**KIRKLEES METROPOLITAN COUNCIL
DEVELOPMENT & MASTER PLANNING SERVICE**

**DELEGATED DECISION FOR PRIOR APPROVAL FOR CHANGE OF USE
FROM COMMERCIAL, BUSINESS AND SERVICE USES TO
DWELLINGHOUSES**

Reference no. 2026/CL/91970/E

Site Address	10, Commercial Road, Skelmanthorpe, Huddersfield, HD8 9DA
---------------------	--

SECOND FLOOR PLAN

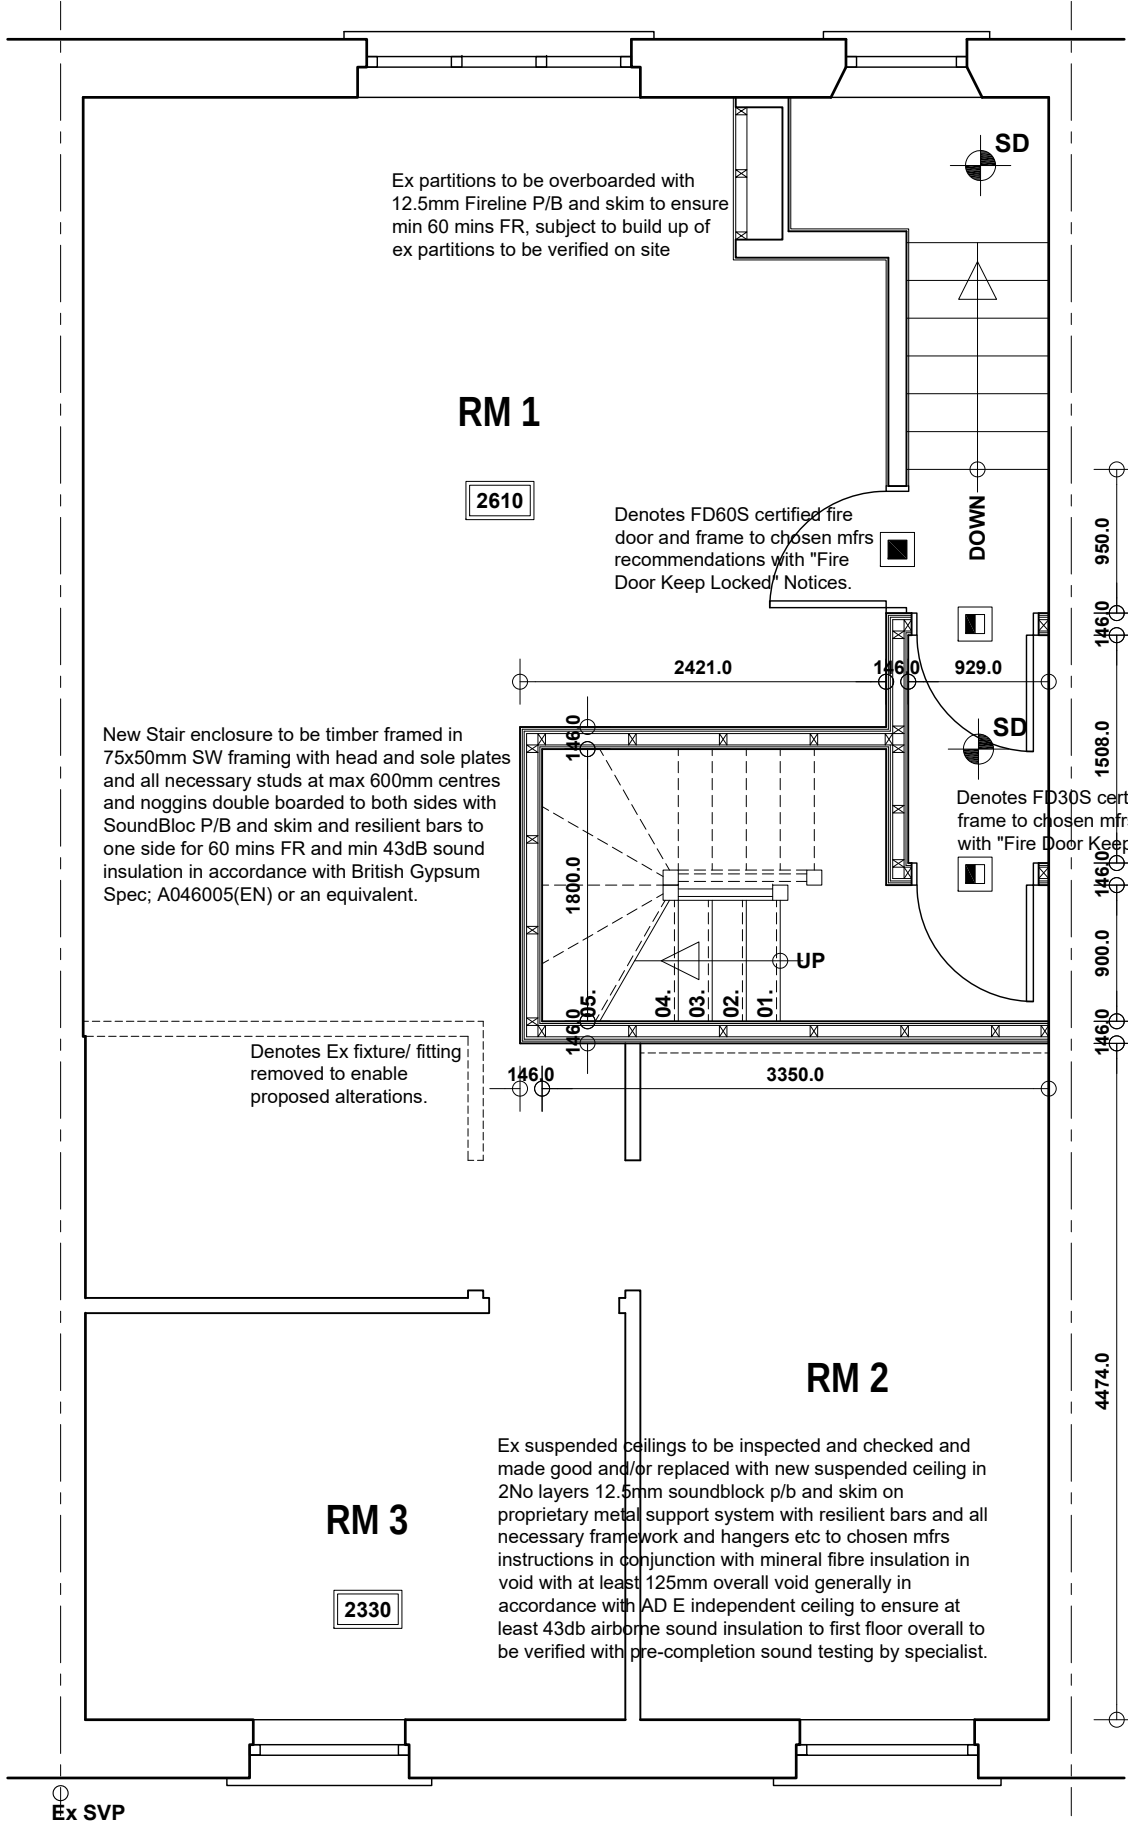
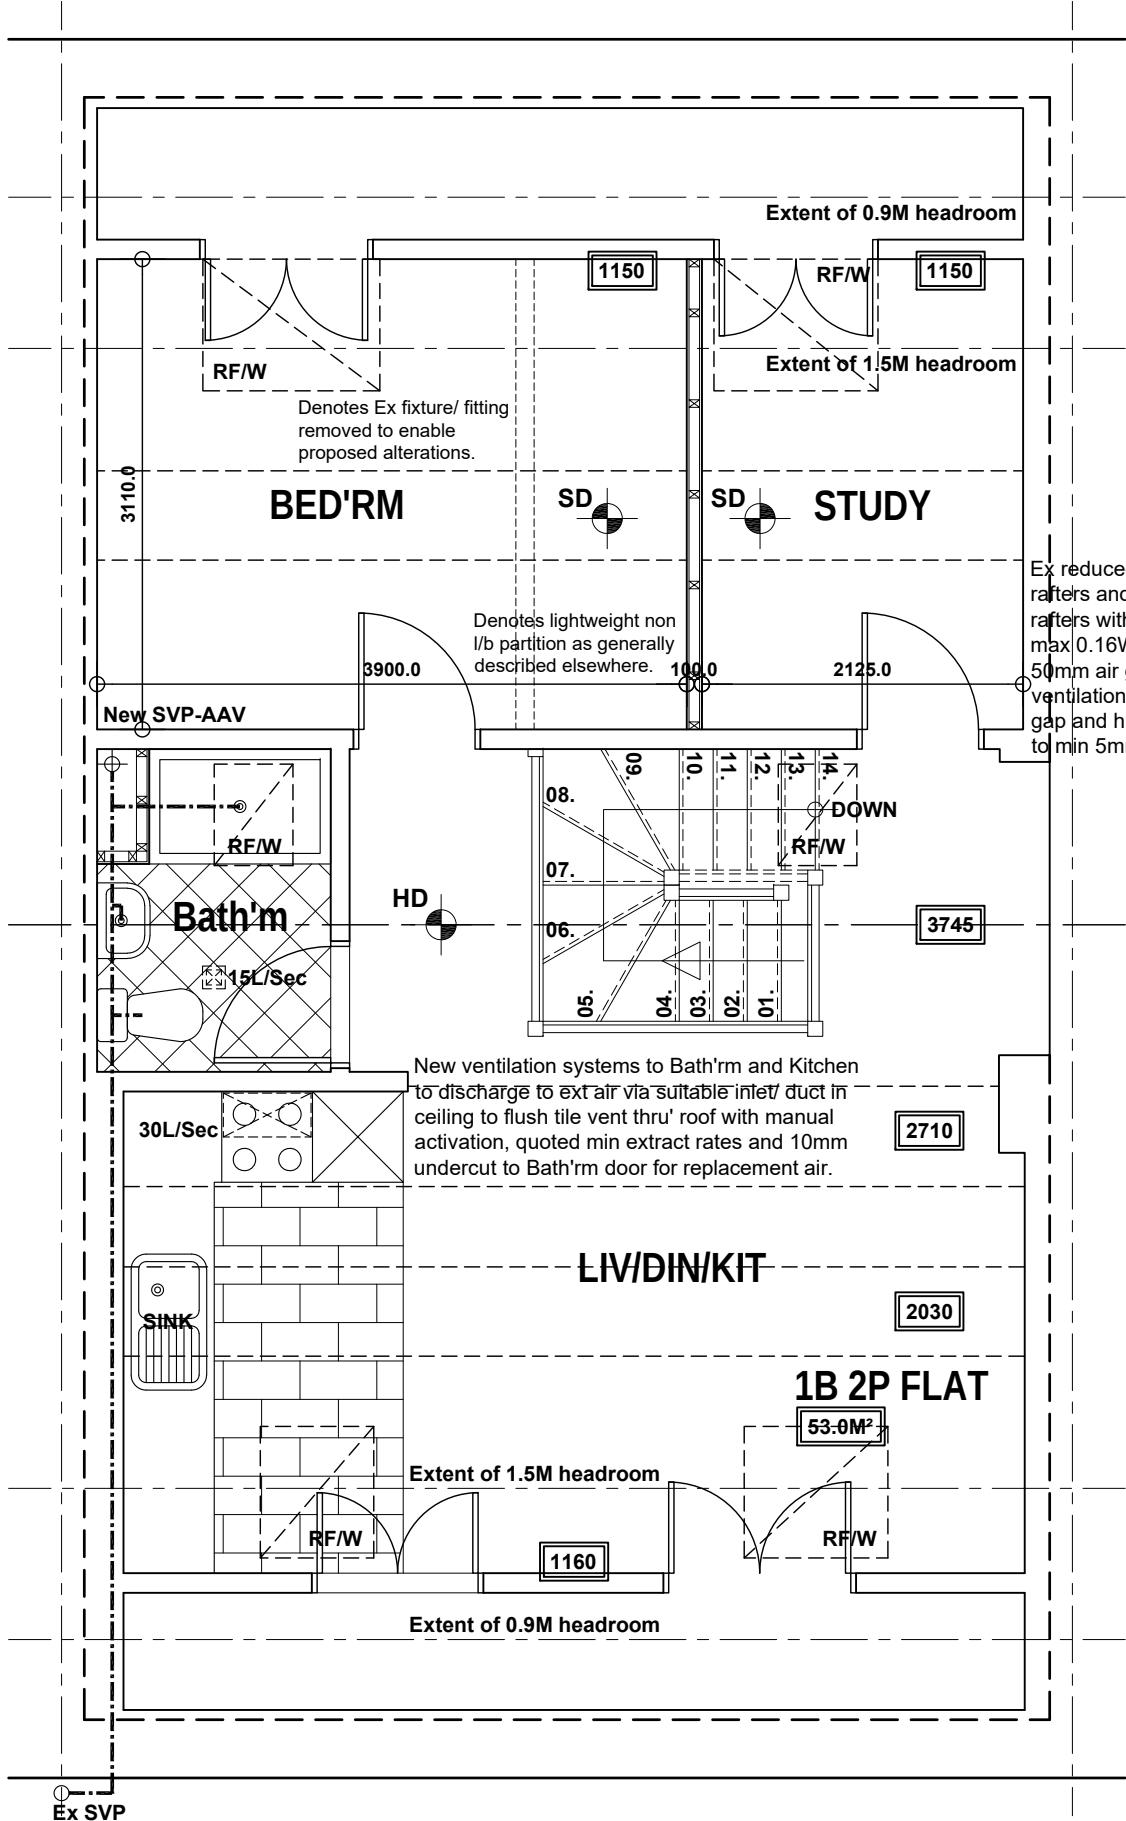
The proposal has been considered against the Government's Space Standards for dwellings which suggest that a single-storey, one bedroom dwelling for two persons should have an internal floor area of 50m² and for one person should have 37m². The proposed floor plans confirm that dwelling would have an internal floor space of 40m², which would be acceptable for a one person dwelling but unacceptable for two persons.

The proposed plans also show a study which officers consider has the potential to be used as an additional bedroom; however, as the proposal is unacceptable in principle due to failing to meet Schedule 2 Part 3 Class MA (As inserted 2021) of The General Permitted Development Order 2015 officers are not seeking clarification of this matter.

FRONT (NORTH) ELEVATION

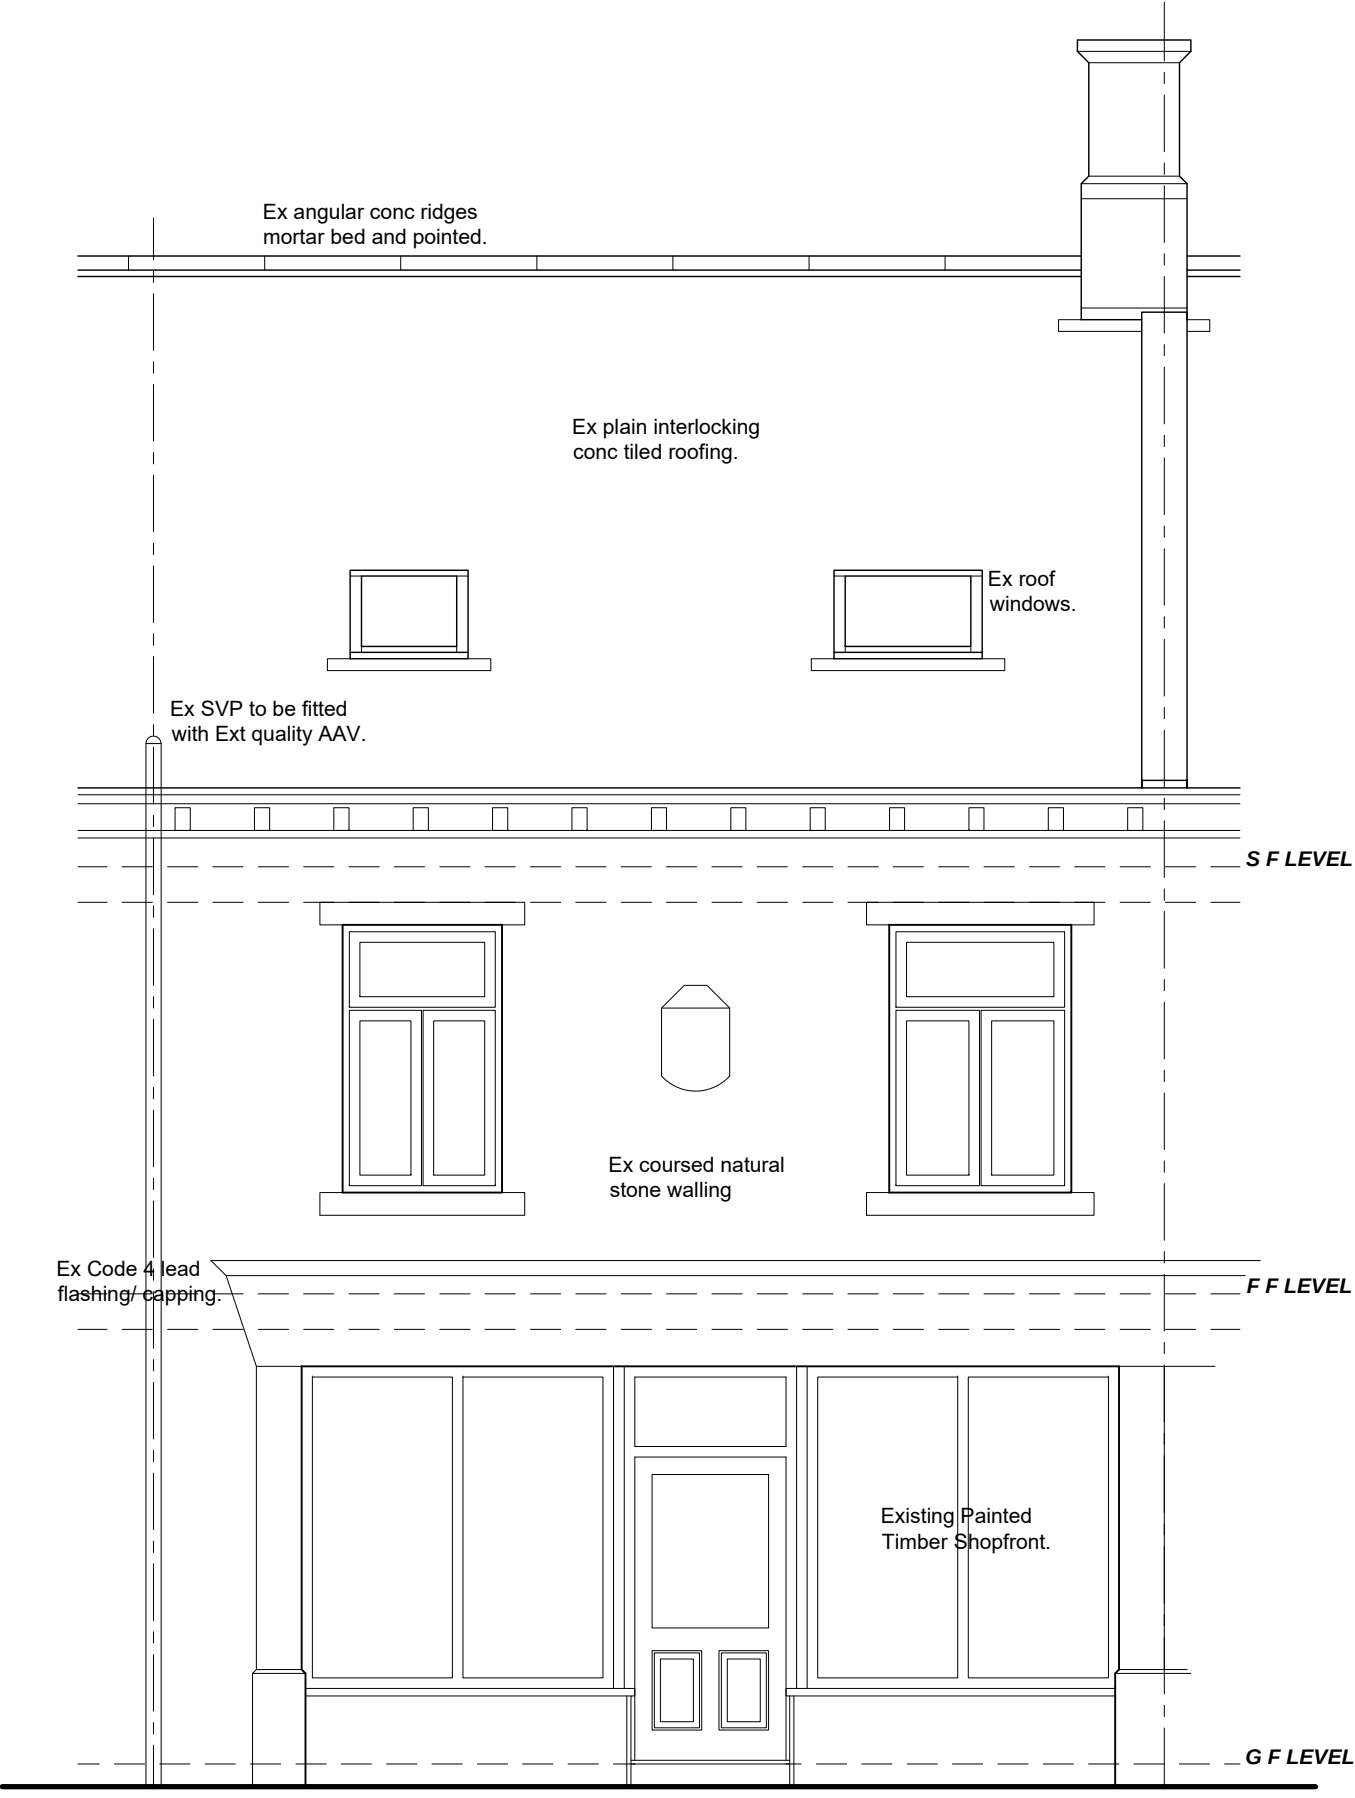
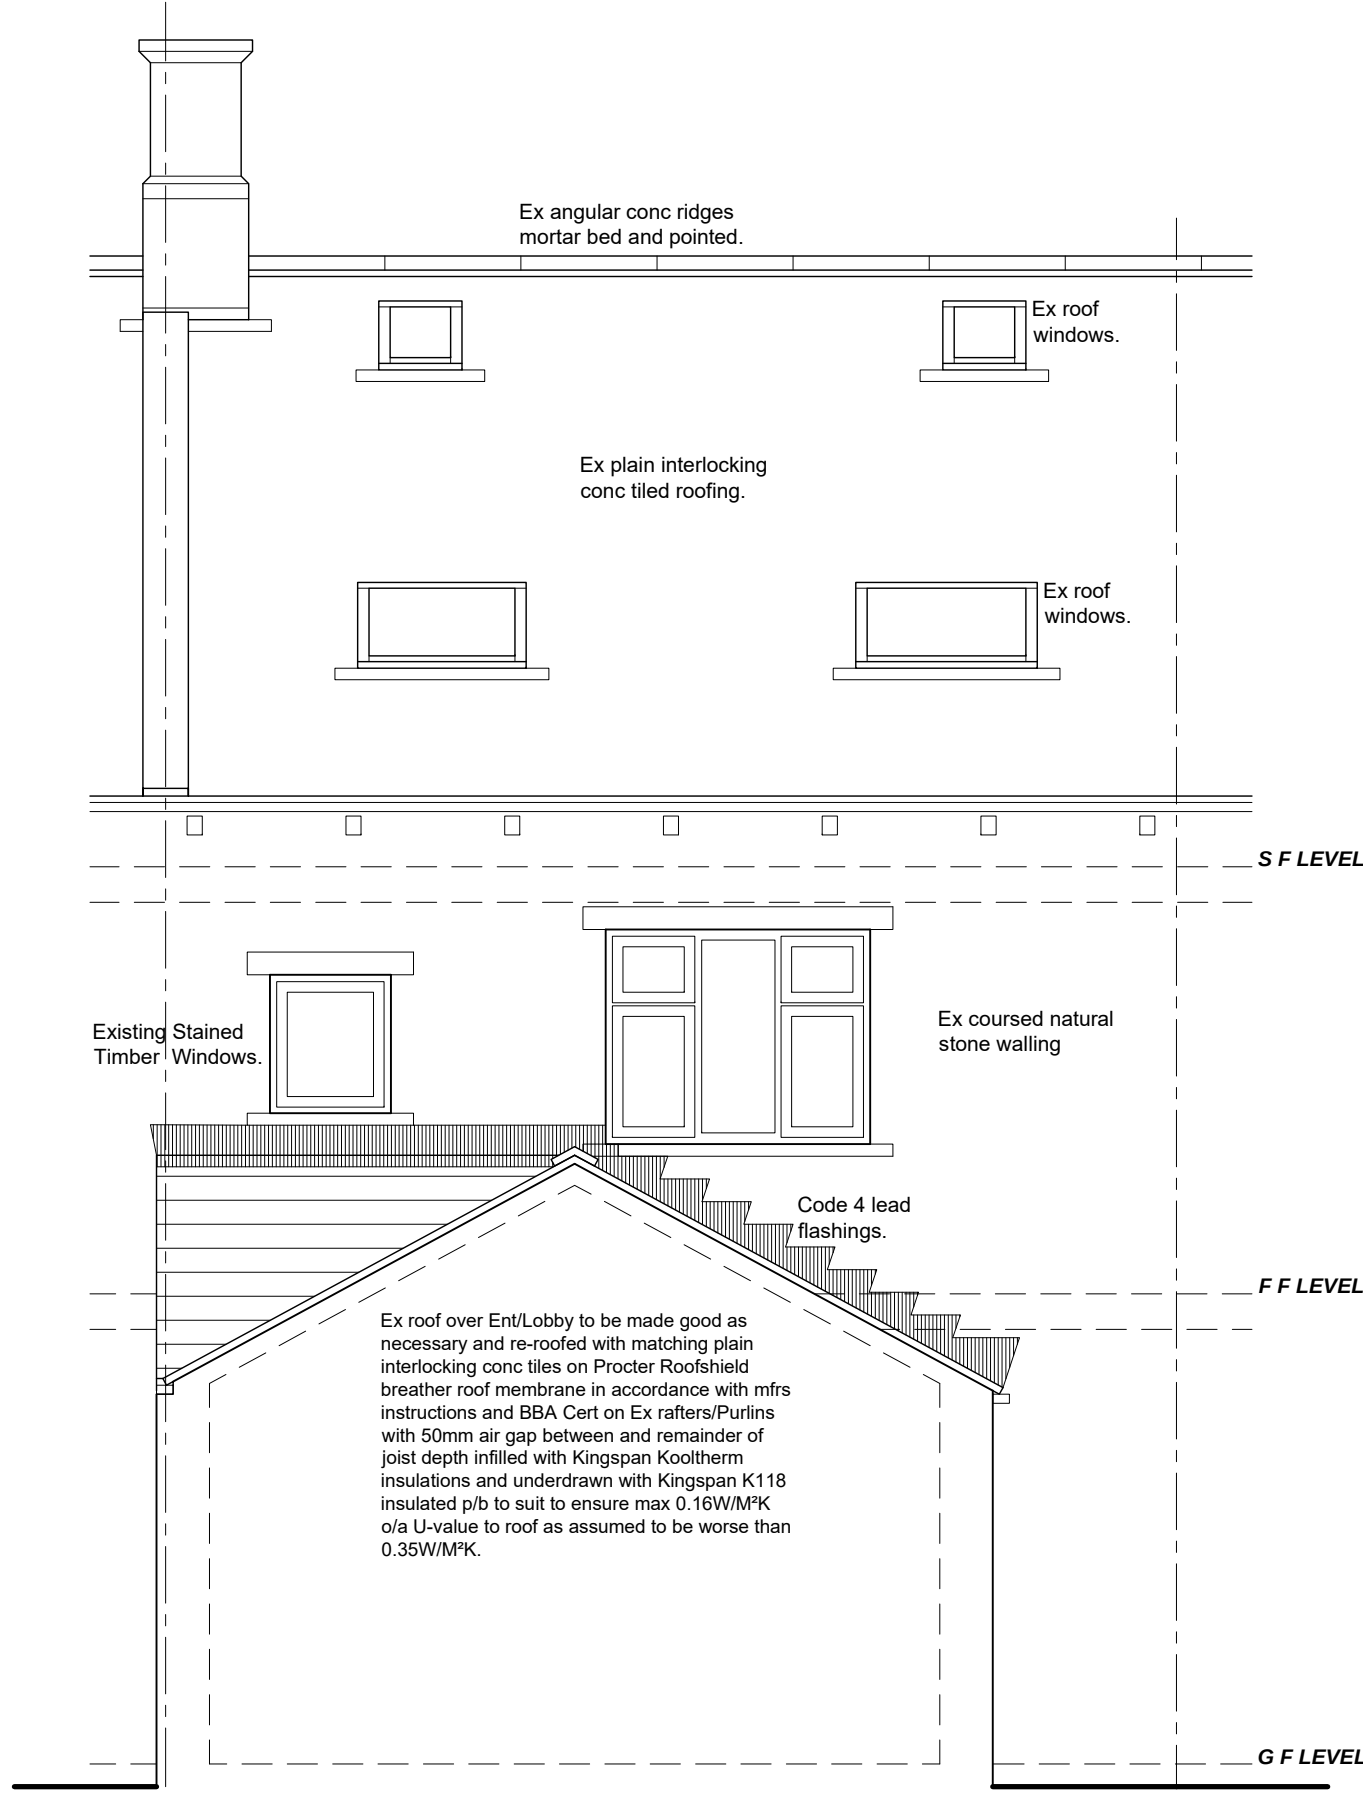
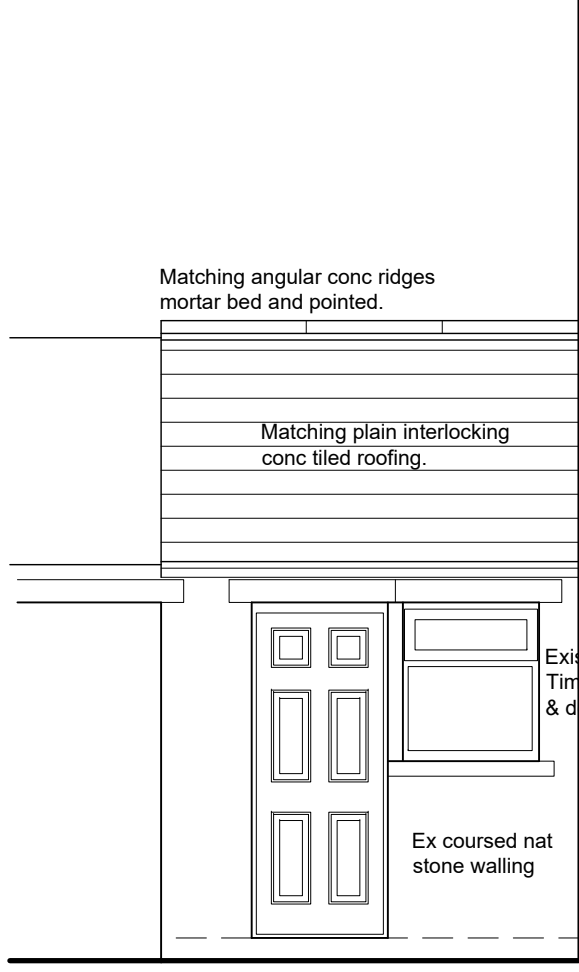
MA.2(2)(f) requires the provision of adequate natural light to all habitable rooms of the dwellinghouse. The submitted plans confirm that the dwelling would benefit from a number of windows to the north, east and west facing elevations which would serve all habitable rooms. Therefore, it is considered

that the property would receive adequate natural light and as such, would be acceptable with regard to MA.2(2)(f).
